DELEGATED DECISION TO DETERMINE PLANNING APPLICATIONS

Reference No:	2023/62/92285/W
Site Address:	23, Aldonley, Almondbury, Huddersfield, HD5 8SH
Description:	Erection of two storey side and rear extensions with loft conversion
Recommending Officer:	Laura Yeadon

DECISION – CONDITIONAL FULL PERMISSION

DRAWING TITLE  
**Proposed Plans**

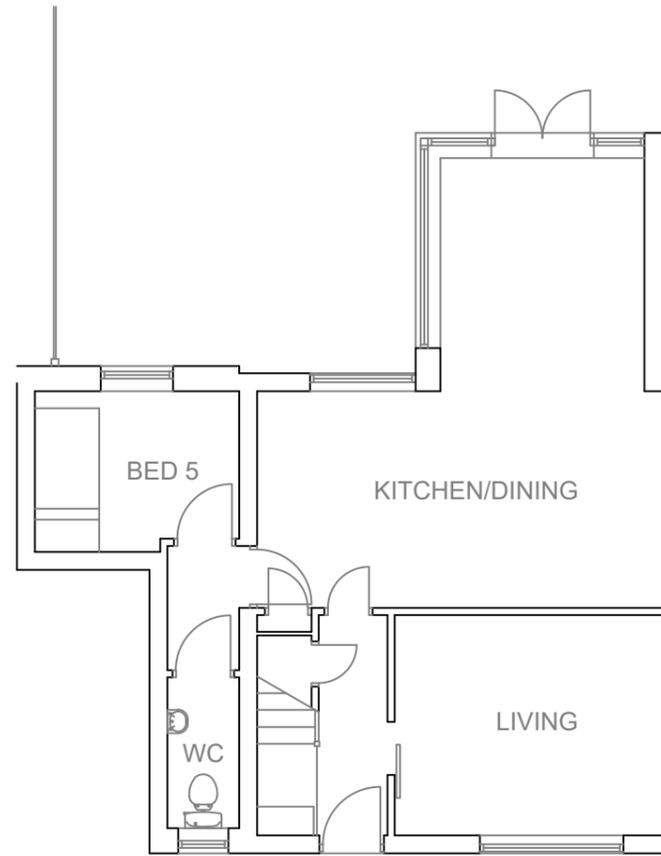
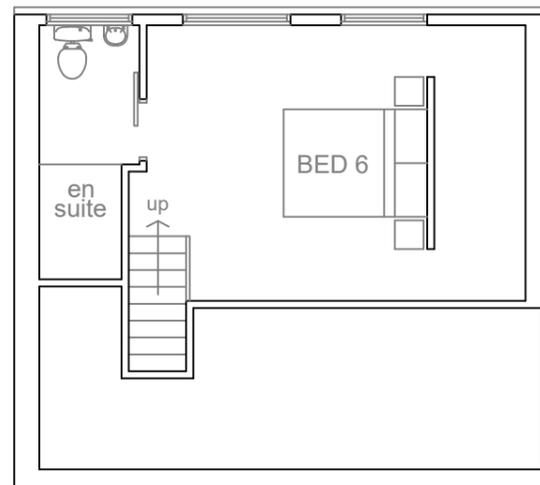
Amended plans were sought to reduce the overall size of the dormer extension and also a 45 degree line demonstrated from the attached neighbouring property's upper floor windows to ensure there would be no undue impact on the amenity of the occupiers of that property.

Key Design Principle 5 of the SPD recommends that the 45-degree rule should be treated as a starting point in assessing impact for all extensions, i.e. a line drawn from the midpoint in the nearest adjacent habitable room window at an angle of 45 degrees should preferably not intersect the extension. In this instance it was considered that the 45 degree line would be impacted by the first floor element of the two storey extension on the first floor neighbouring openings and therefore amended plans were sought to demonstrate any harm to this neighbouring property.

In response, amended plans were submitted on 20th February 2024 that demonstrated a reduction in the overall size of the dormer, changed the roof form of the two storey rear extension from a shallow pitched roof to a flat roof and also a chamfered corner on the first floor element of the rear extension to achieve a 45 degree line. These amended plans form the basis of the assessment.

The agent has submitted amended plans which show that the extension would comply with the 45-degree rule with respect to the large window in No. 25 and as a result has chamfered the corner of the first floor element of the extension to ensure that the 45 degree line would not be cut.

DRAWING TITLE
Proposed Elevations

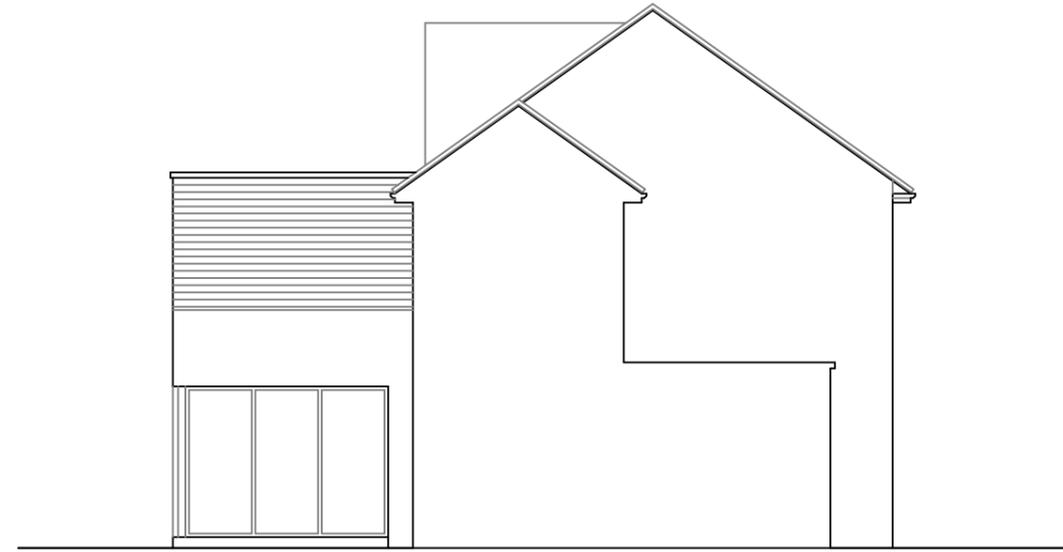
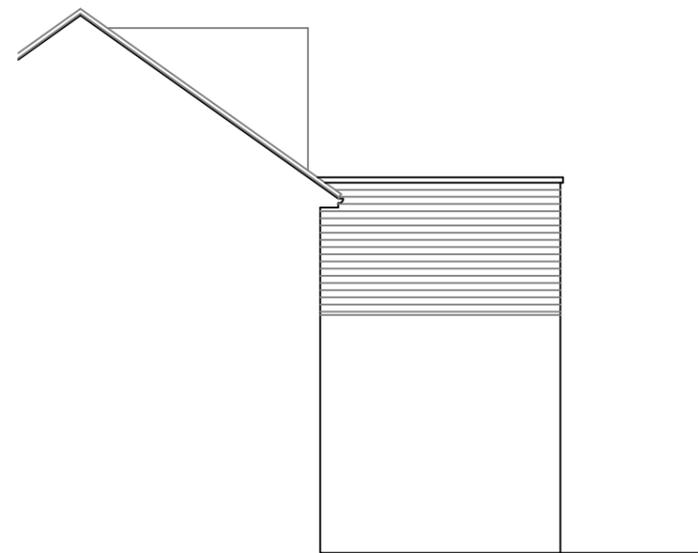
There is a dormer proposed within the rear elevation roof slope which has been slightly reduced in size from the original submission, at the request of the Case Officer. The dormer would sit within the confines of the existing and extended roof form and therefore relates to the appearance of the house and existing roof, it can be conditioned to be a matching colour to the existing roof and would be set up from the gutter line and down from the ridge with acceptable fenestration details. As such, in terms of visual amenity, the resultant impact of the dormer would be acceptable.

4. The dormer extension shall be either tile hung to match the existing roof or shall be finished with cladding of a dark grey colour finish and be retained thereafter.
